Fiveways Crows Nest
391-423 Pacific Highway,
Crows Nest

Access Review – Final

1 September 2023

Drawing Title
Adaptable Plan Layouts (DA Stage)
Adaptable/Livable Layouts

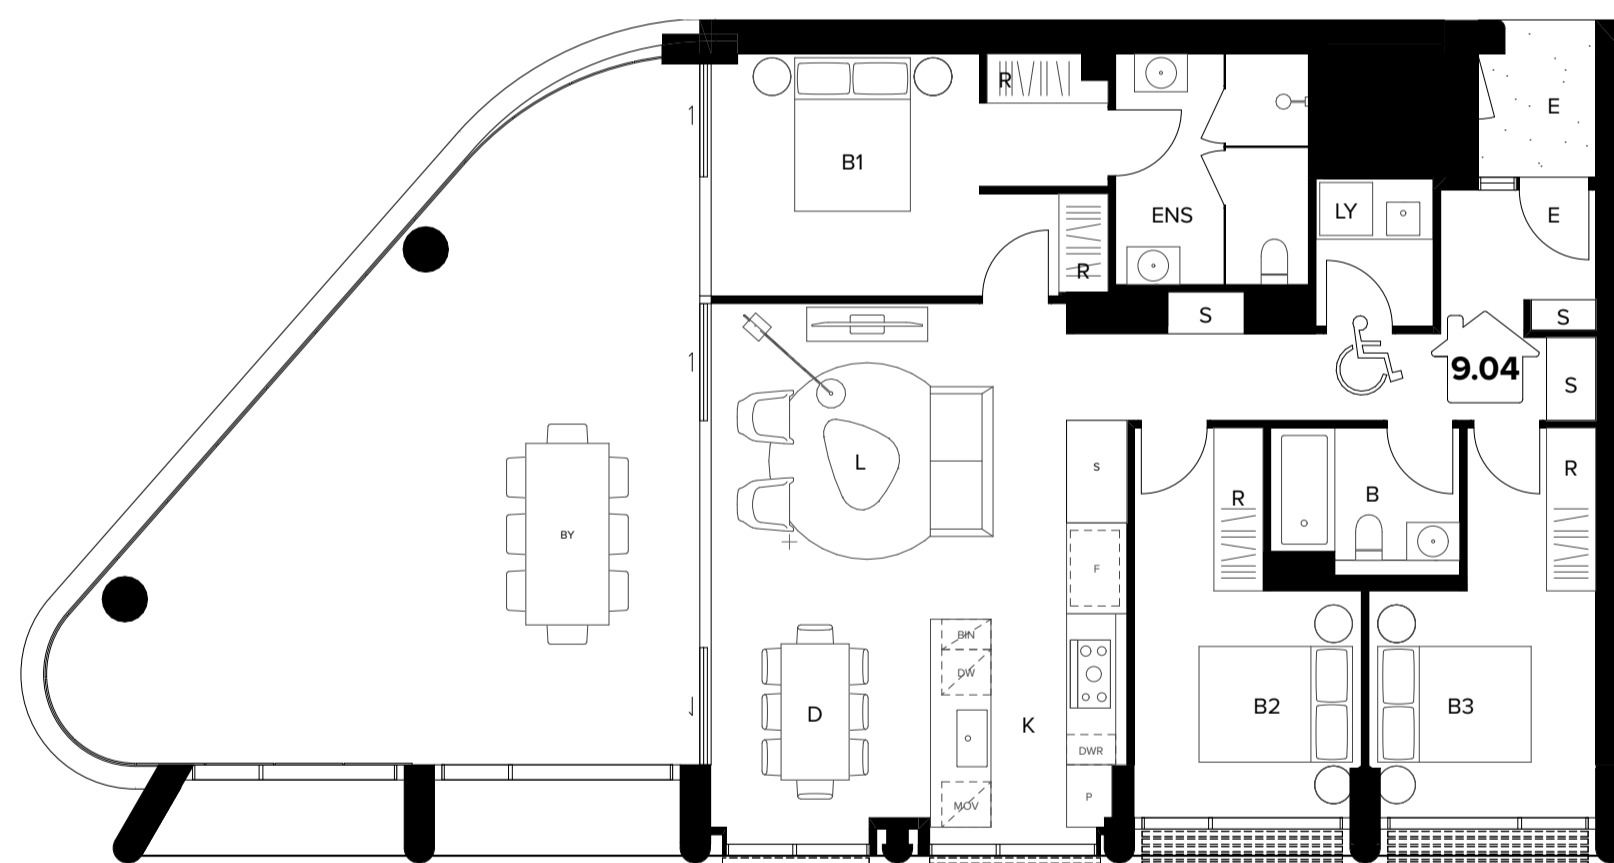
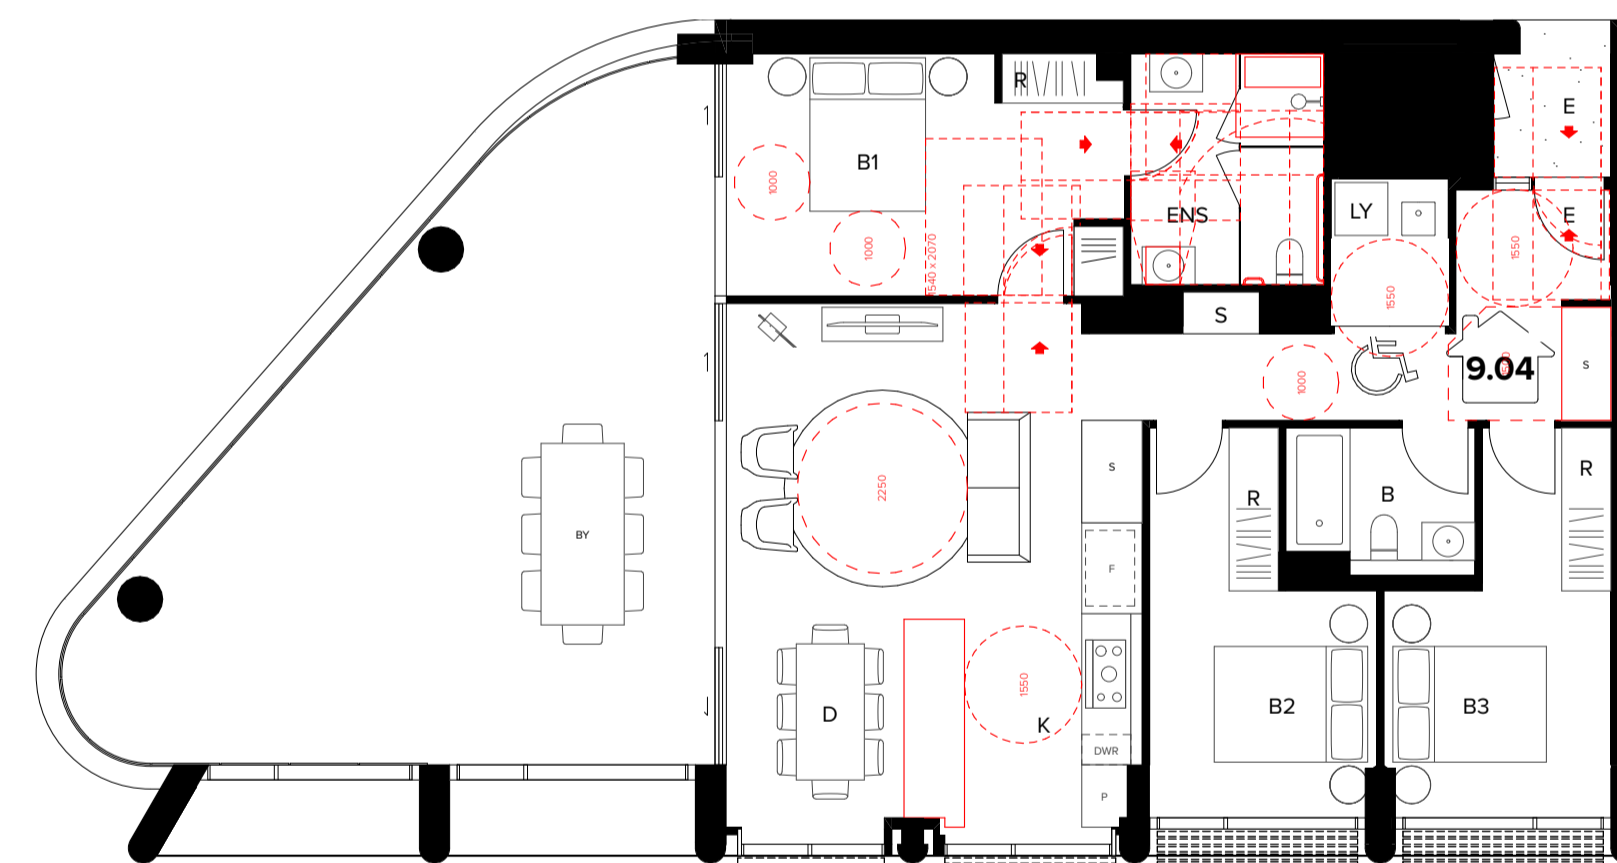
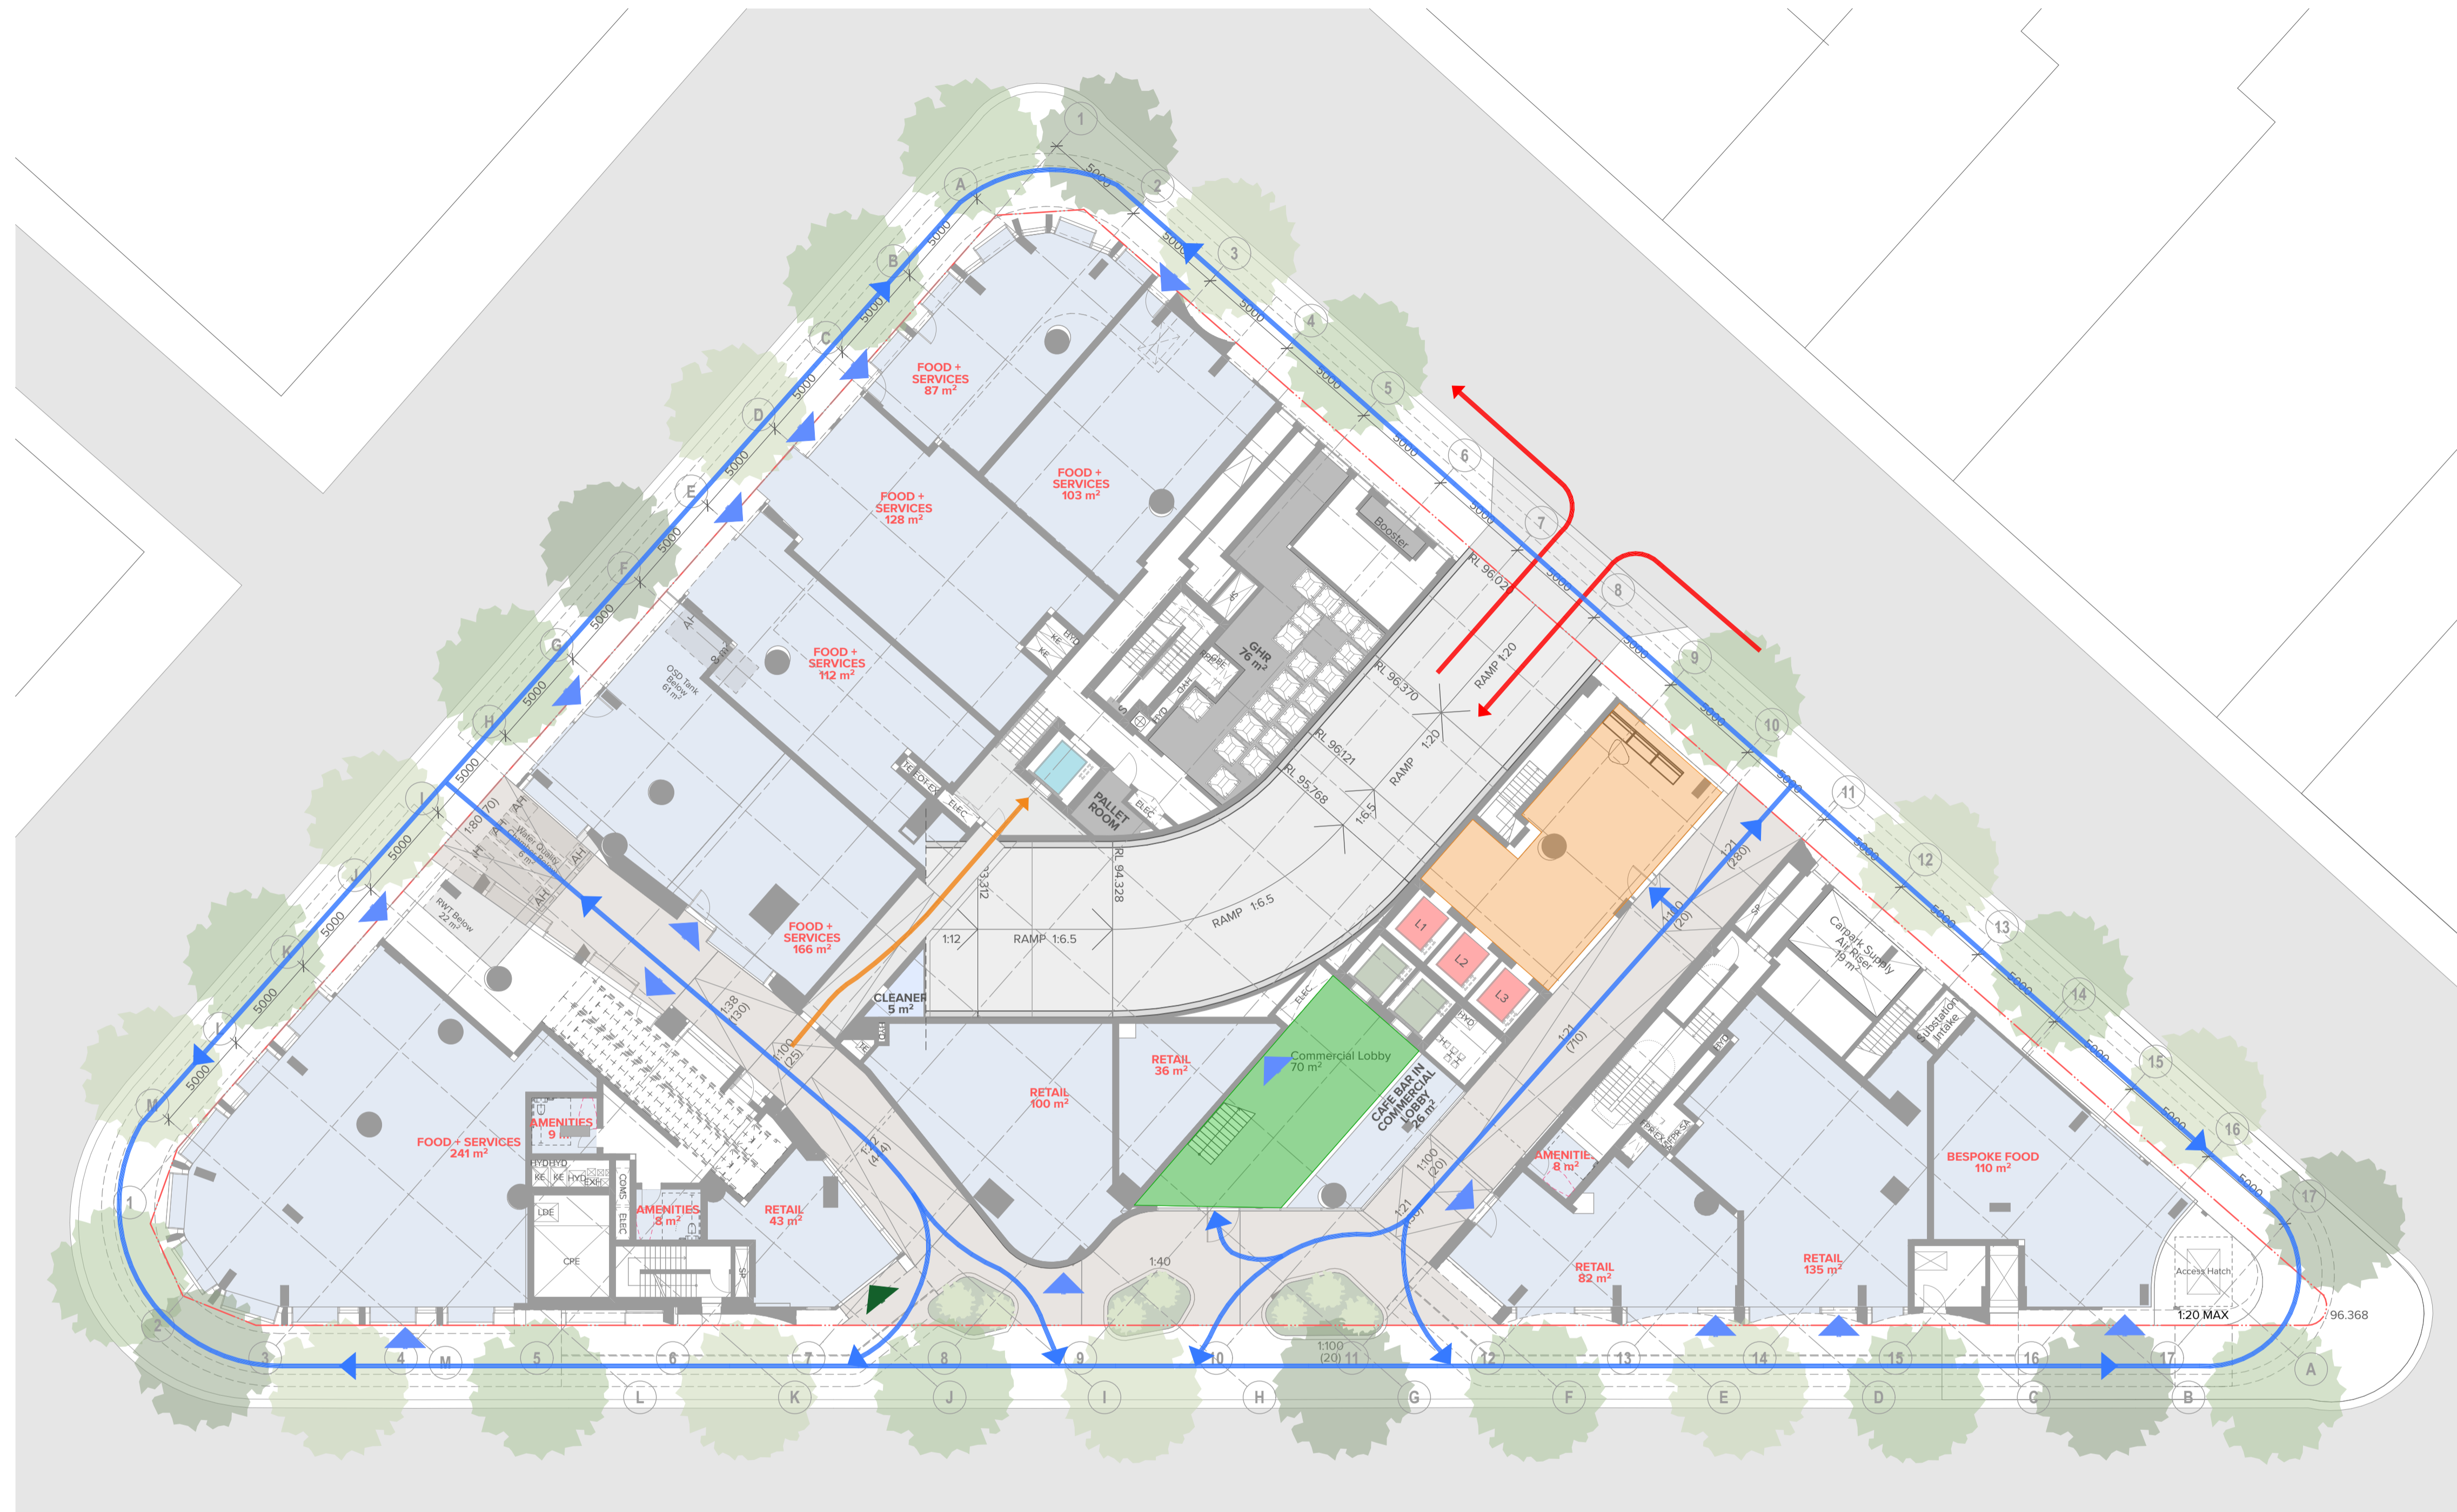
In general, the two adaptable unit types show appropriate compliance with the requirements of AS42999 at this point of the design process. Minor review is required of the 2B05 type entry door circulation and the 3B01 type corridor to ensure AS1428.1 requirements are met, however compliance is readily achievable.
